## Kurri Kurri Lateral Pipeline Project update

APA Group is pleased to provide an update on the Kurri Kurri Lateral Pipeline Project (KKLP – the Project).

## Attachment 1 – Design refinements

**Buchanan Road - East**

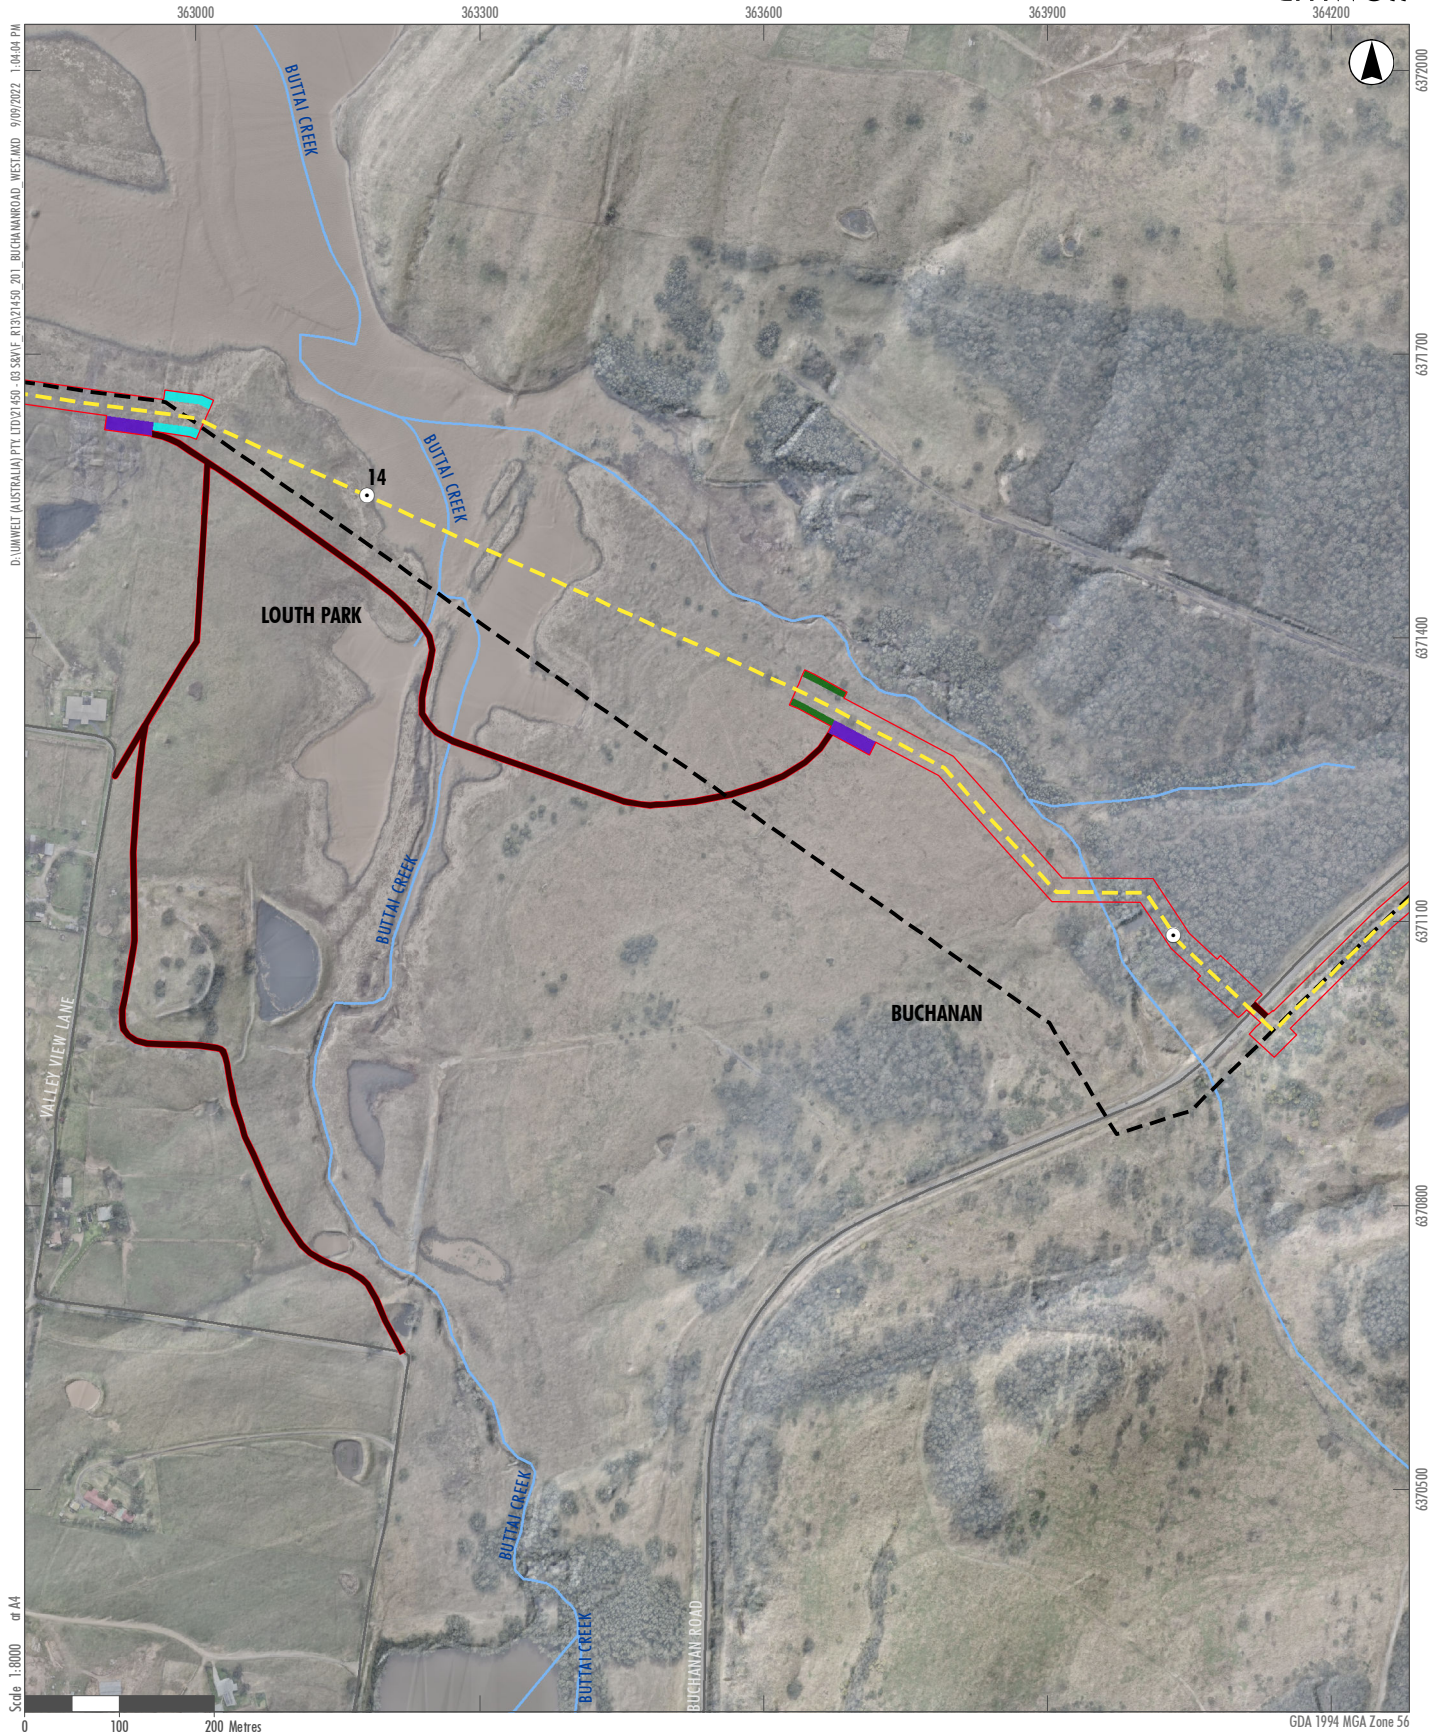
APA has held ongoing discussions with the landholder (Ashtonfields) regarding the positioning of the alignment between approximately KP11.0 and Buchanan Road. The key constraints for the transmission pipeline alignment in this area are existing residential areas immediately north of Lot 1 DP 1045723, old underground mine workings, remnant vegetation, and potential residential development following completion of mining operations.

The preference of the landholder is for the alignment to follow Hunter Water trunk mains to the north-west, then the northern and western boundaries of Lot 1 DP 1045723. No new landholders are directly affected by this option, as shown in the figure below.

Buchanan Road - West

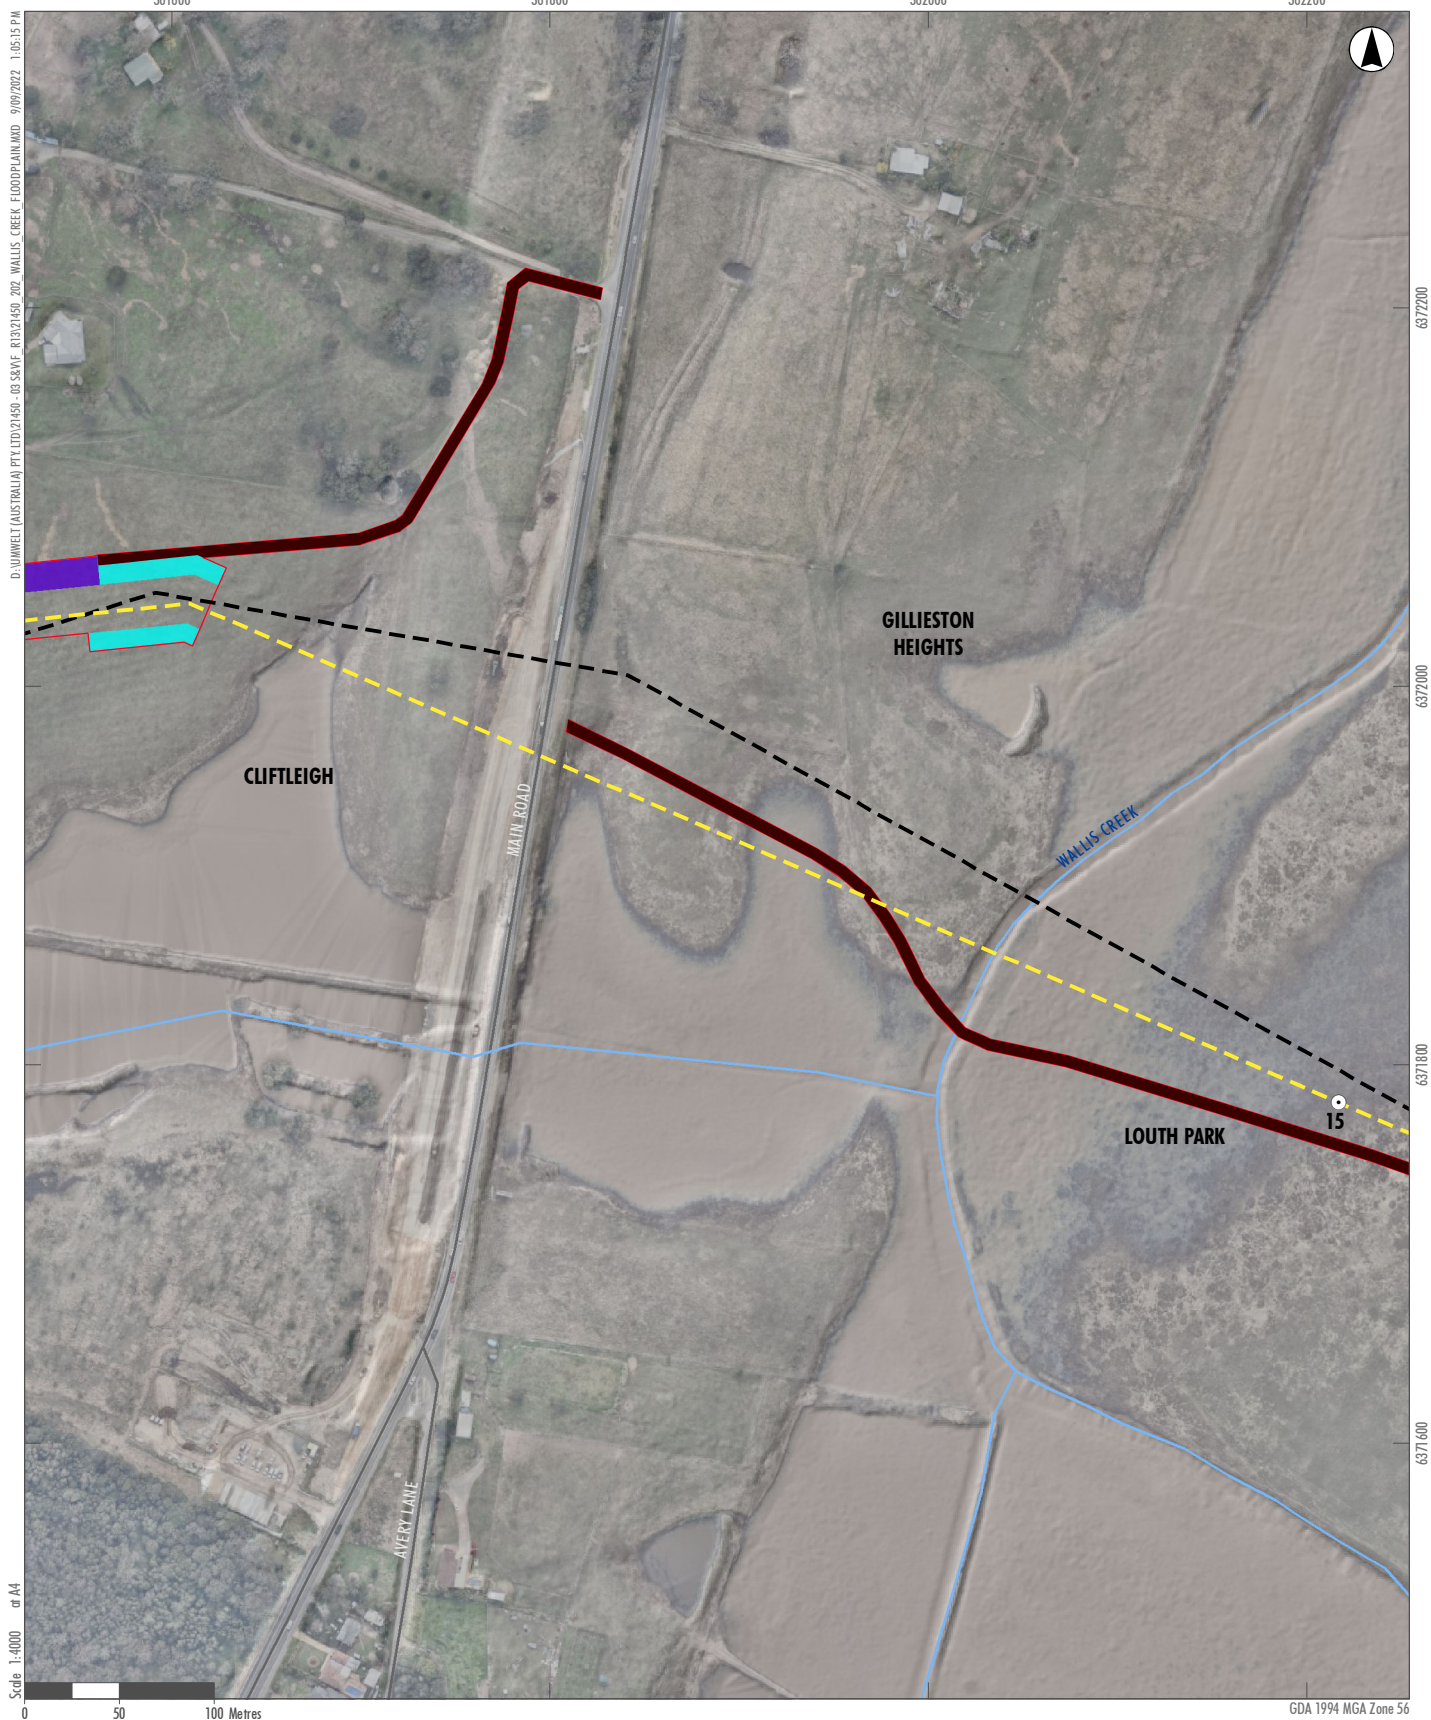
Further discussions with the landholder (Ashtonfields) and mining lease holder (Bloomfield) have sought to refine the EIS alignment between Buchanan Road and Buttai Creek. Key constraints in this area are old underground mine workings, partially rehabilitated coal fines stockpiles and dams from previous coal mining operations, proposed residential development following completion of mining operations, remnant vegetation and flooding extents.

A refined alignment has been developed which avoids partially rehabilitated coal fines stockpiles and dams, minimises impacts to potential future residential areas and is positioned above key flood extents. Overall, this alignment represents a minor change from the alignment presented in the EIS, with no new landholders impacted, and no material change to cultural heritage, noise, and air emission impacts during construction. Impacts to native vegetation increase marginally as the construction footprint will impact a small area of PCT 590, Spotted Gum – Broad-leaved Mahogany – Red Ironbark shrubby open forest.

The alignment modification is shown below. In principle agreement has been agreed with the landholder (Ashtonfields) and mining lease holder (Bloomfield) for this alignment.

**Crossing of the South Maitland Coalfields**

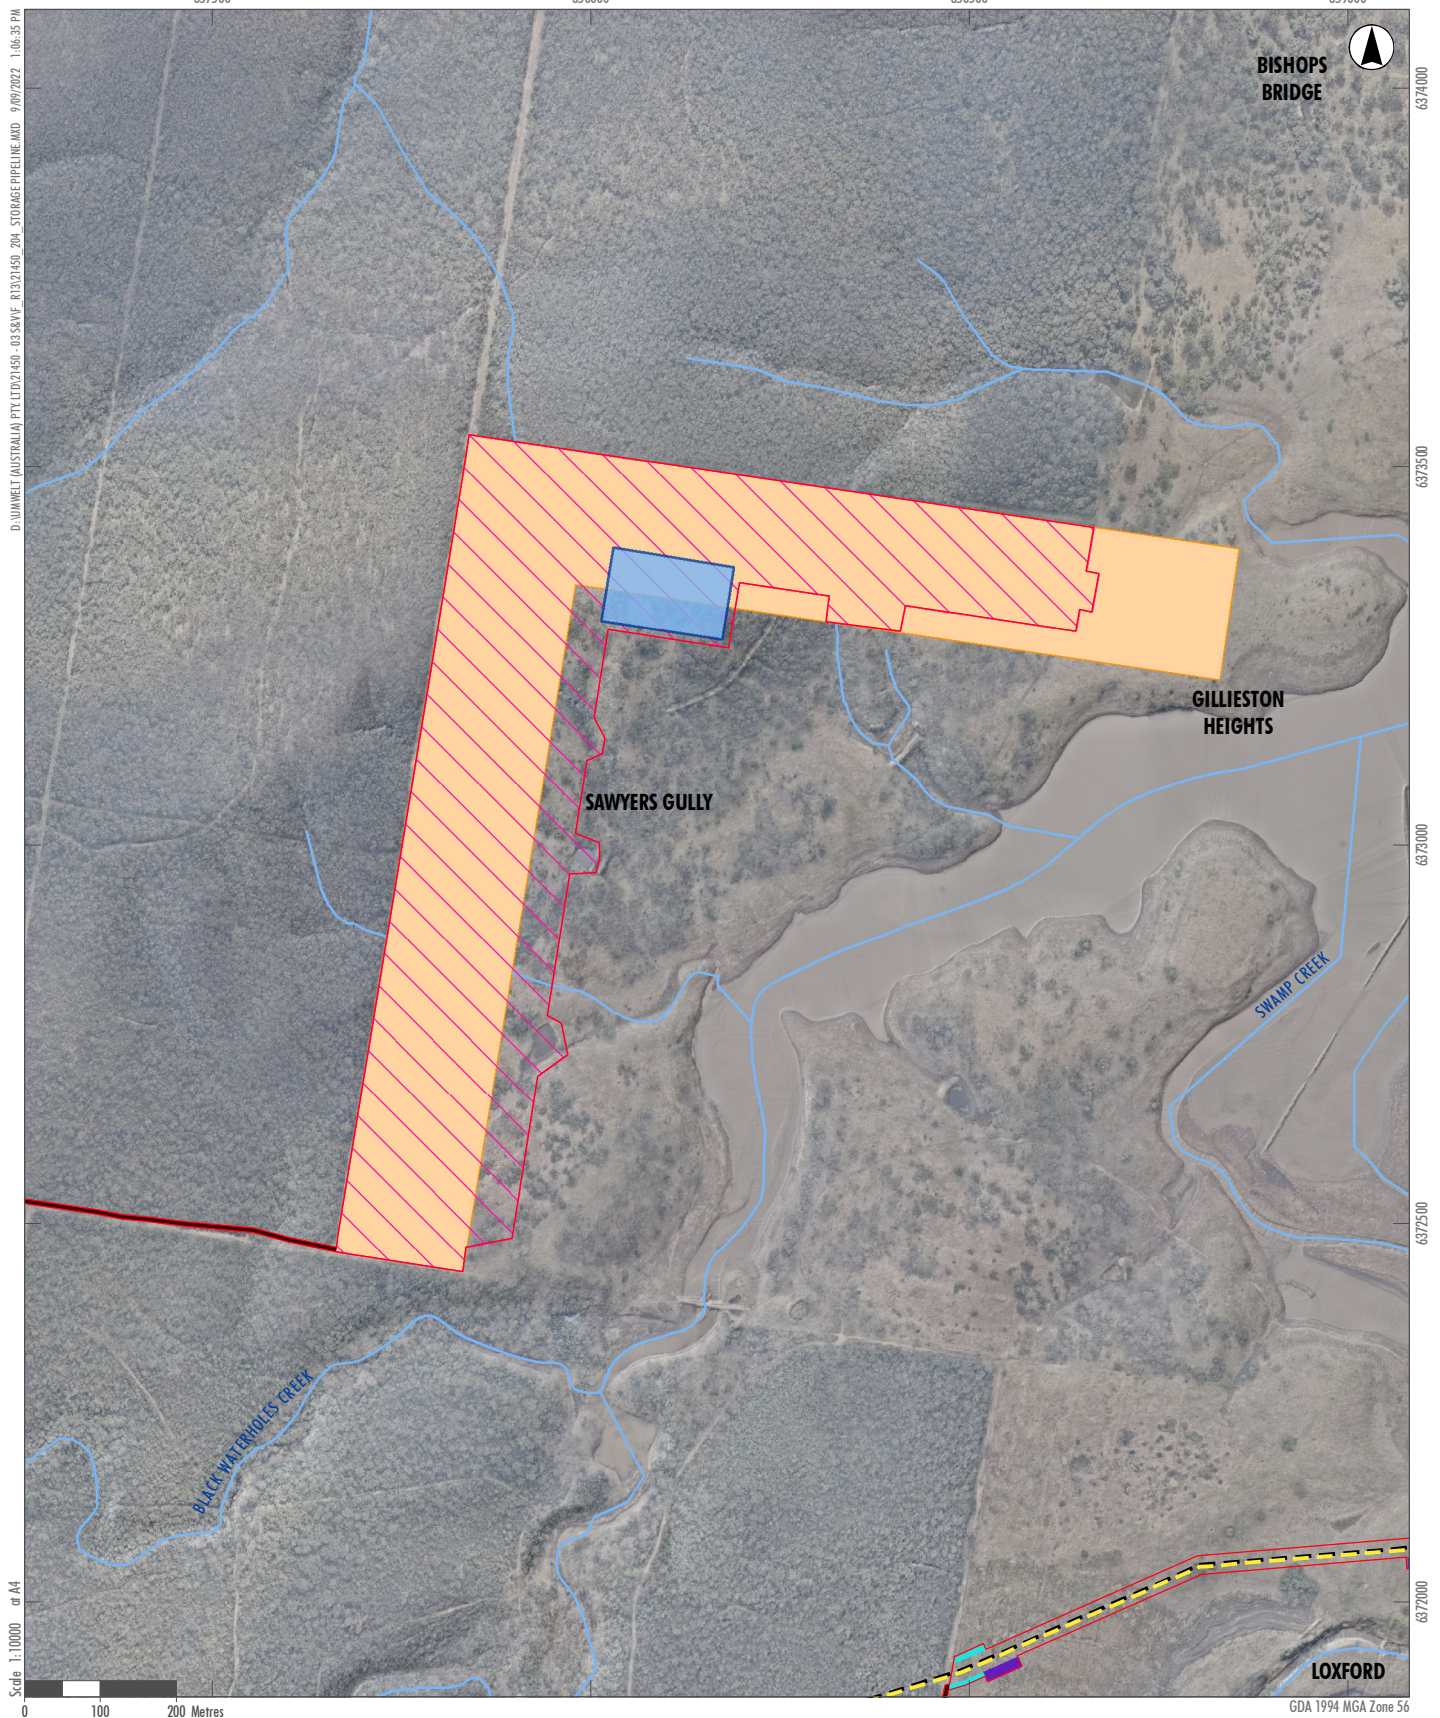
Further technical investigations of the proposed crossing location have been undertaken and a minor refinement to move the alignment 10m to the north is proposed. This refinement will further mitigate mine subsidence risks by locating the pipeline above sections of the underground workings that have previously subsided. Environmental impacts for this minor refinement are commensurate with those presented in the EIS.

Storage Pipeline

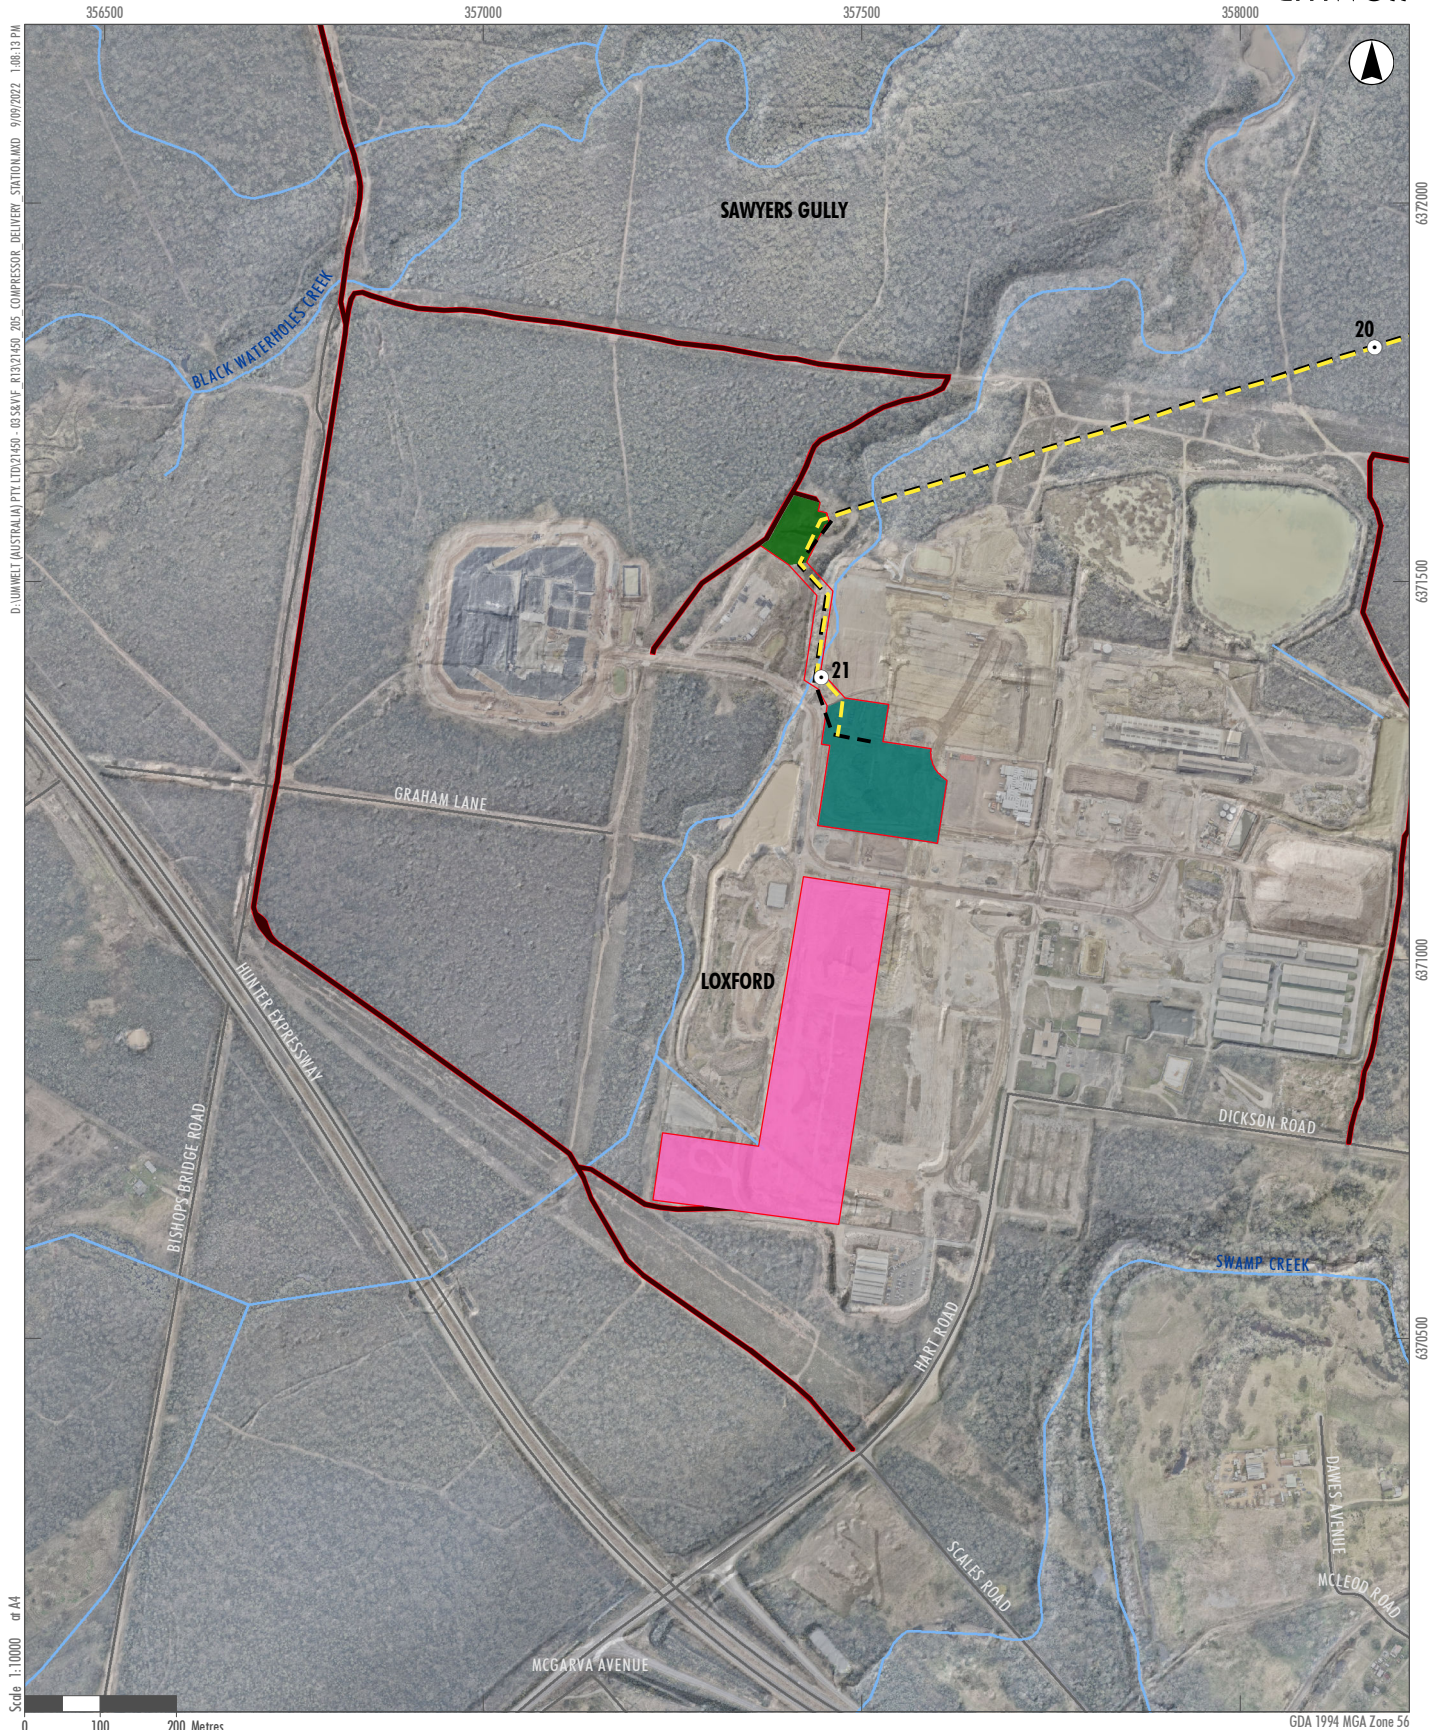
The construction footprint for the storage pipeline has been refined to minimise impacts to the river-flat eucalypt forest TEC (BC Act endangered, EPBC Act critically endangered), reduce the extent of construction within an east-west trending gully and avoid the area of lowest elevation with potential for flooding and acid sulfate soils. This has been achieved by reducing the length and width of the E-W section of the storage pipeline, and a commensurate increase to the width of the N-S section. In addition, areas for sediment dams have been included in the construction footprint based on runoff calculations. A commitment to investigate of options to minimise impacts to the river-flat eucalypt forest community at the north-eastern extent of the storage pipeline footprint was included in the EIS as a mitigation measure (B09).

Overall, the construction footprint has increased slightly from 33ha to 35ha. The estimated area of impact to river-flat eucalypt forest has reduced from 3.3 to 1.2 ha (BC Act) and marginally increased from 1.1 to 1.2ha (EPBC Act).
